From: [REDACTED]
Sent: 04 September 2018 09:23
To: Zac Denton
Cc: Vincent Baritsch
Subject: 2 Elmer Court - M/92/18/HH
Importance: High

Re: 2 Elmer Court, Elmer, Middleton- on- Sea, PO22 6JT

Planning application M/92/18/HH - Replacement two storey rear extension, balcony & alterations (resubmission following M/62/17/HH).

Job:
2 Elmer Court
Bognor Regis
Proposed Replacement
Two Storey Rear
Extension
and Alterations

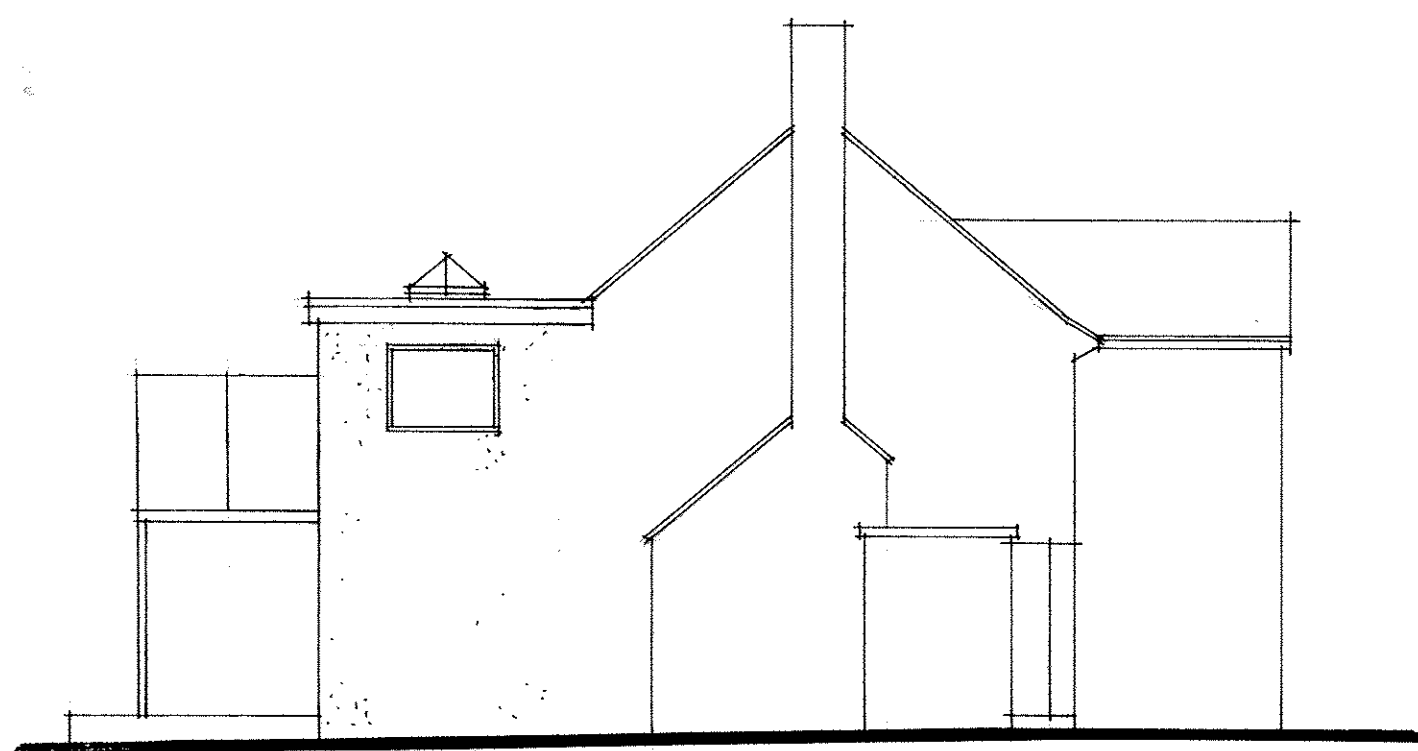
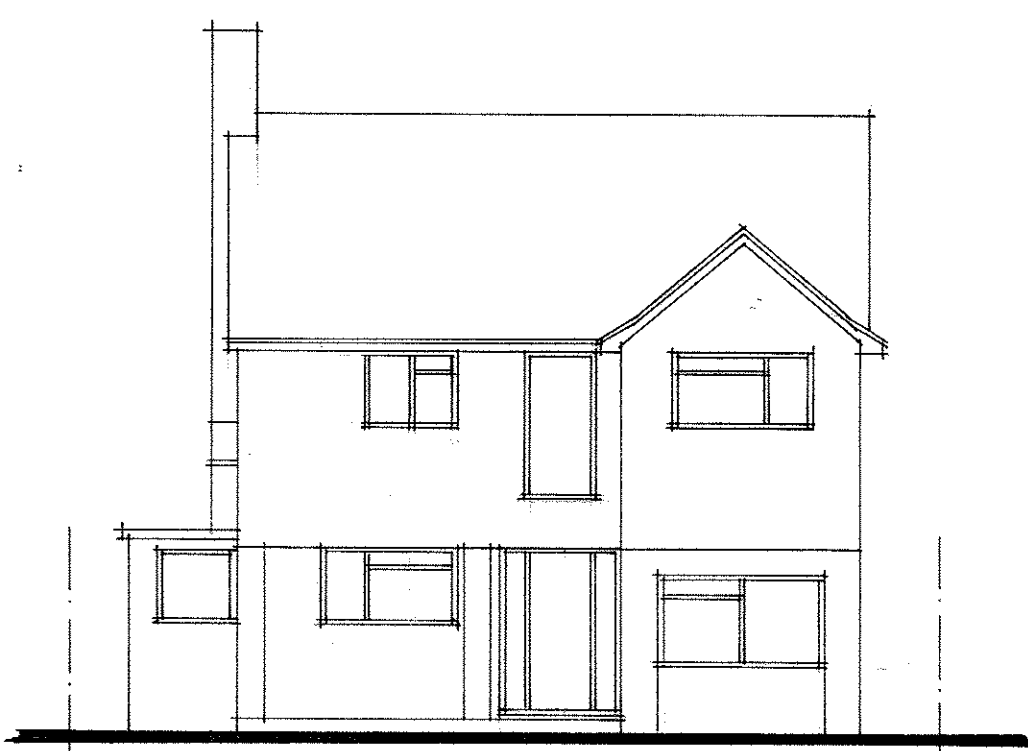
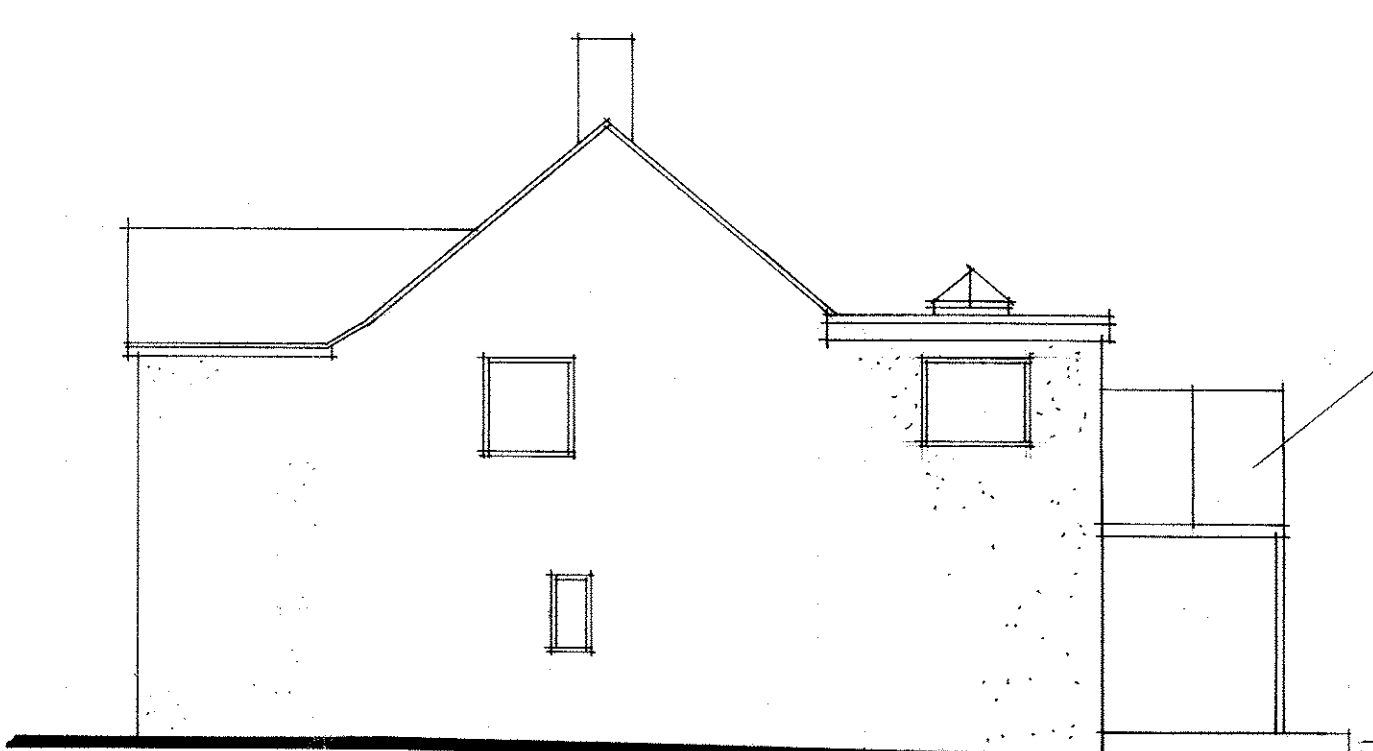
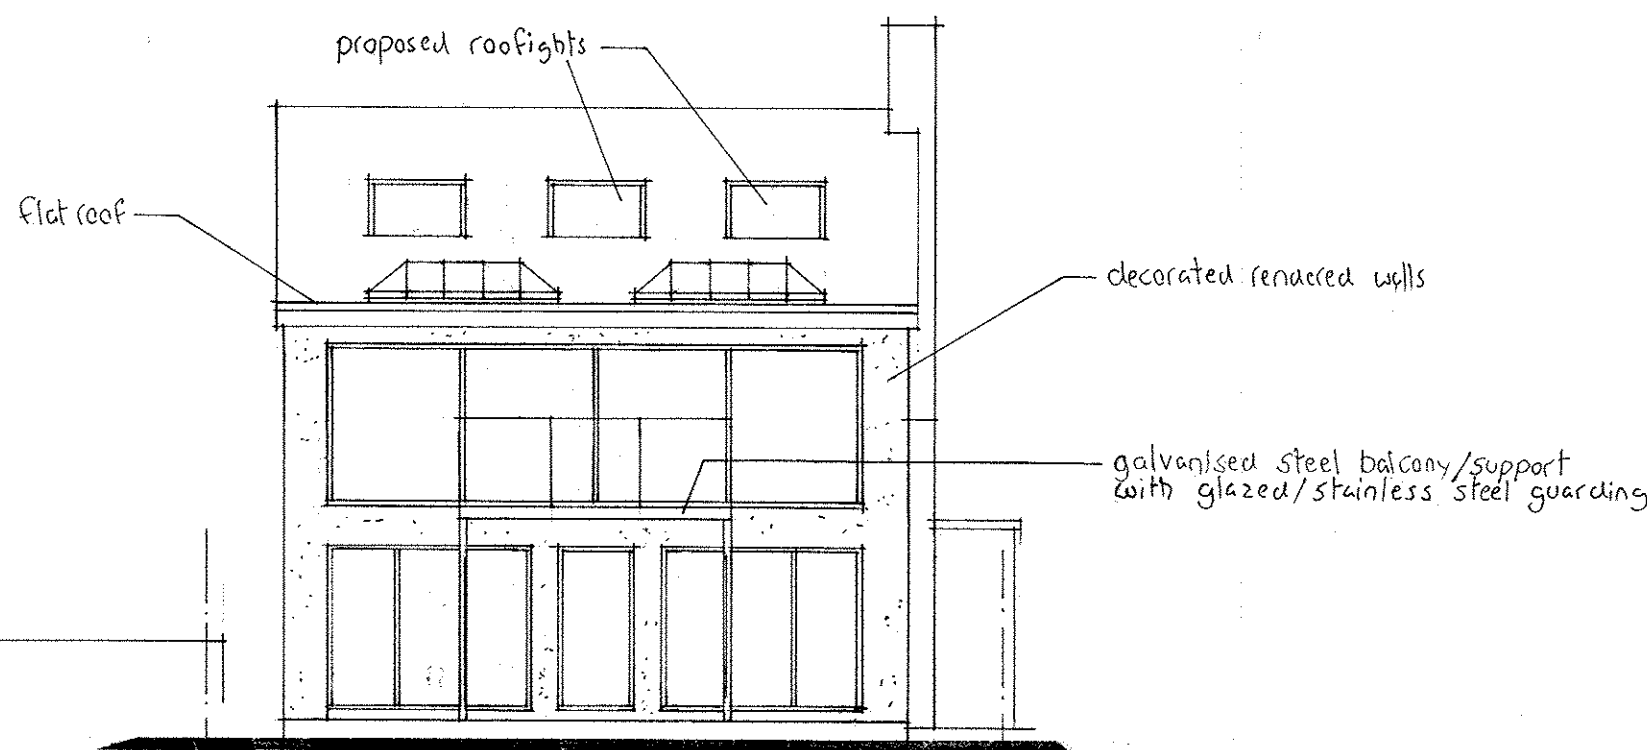
As an aside you will note from the second photograph that the current appearance of the wall of the extension is black. I do not know if this is their intended final colour. Condition 3 on the original consent states:

In my professional judgement a black finish would be incongruous and result in a considerable overbearing effect on my client's property. Please ensure that the render matches the original house, and that such a colour is retained in perpetuity.

First Floor Plan

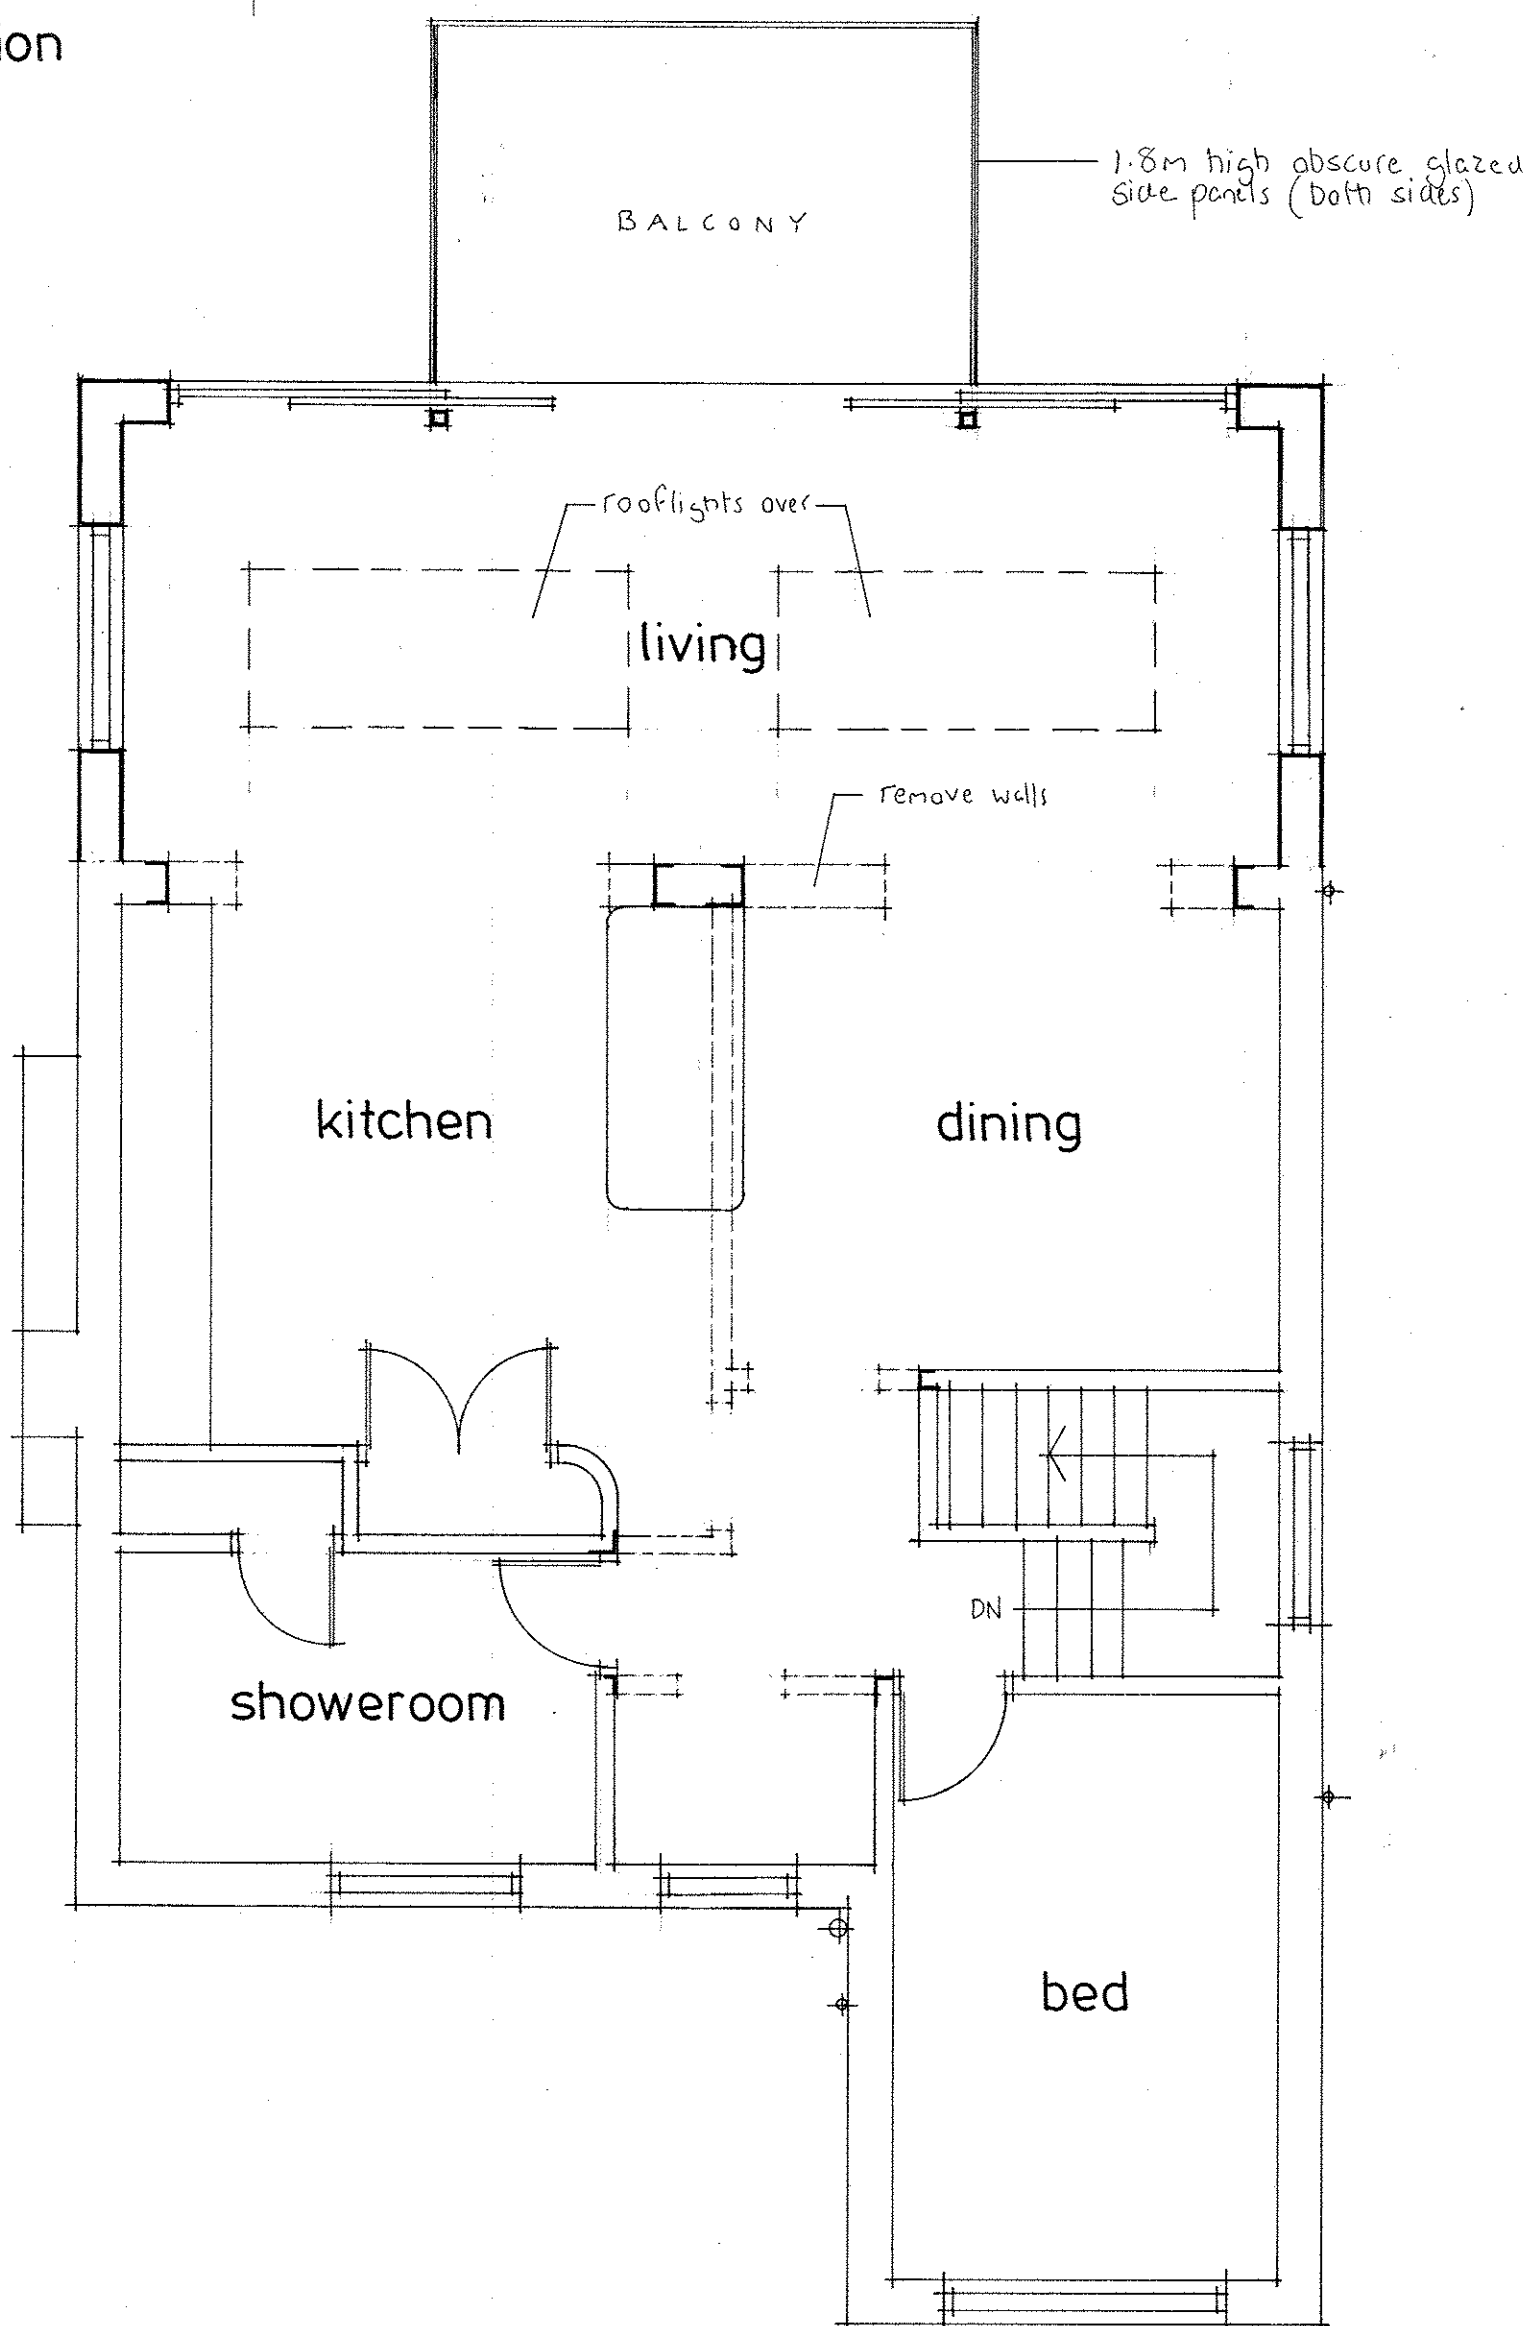
The objection relates to the side window serving the living room extension.

My client's property is set further back from the beach than the application property with a result that the first floor bedroom windows look onto the two storey extensions side wall.

The photograph above shows the relationship of the side window with the rear facing window of his youngest child's bedroom, as taken from their bedroom window – it is clear that direct overlooking will occur, resulting in very unacceptable loss of privacy for his youngest child.

From the above evidence it is plain beyond peradventure that the subject clear glazed side window is wholly unacceptable, gives rise to severe overlooking. It is therefore clearly contrary to policy D DM4.

Accordingly, a condition MUST be imposed on any permission for this amended scheme to the effect that:

"The first floor accommodation shall not be used / occupied until the existing clear glass in the first floor side window in the extension facing 1 Elmer Court has been replaced with obscure glazing at a minimum of Level 4 on the Pilkington scale of obscure/textured glass. Thereafter the obscure glass shall be retained in perpetuity."
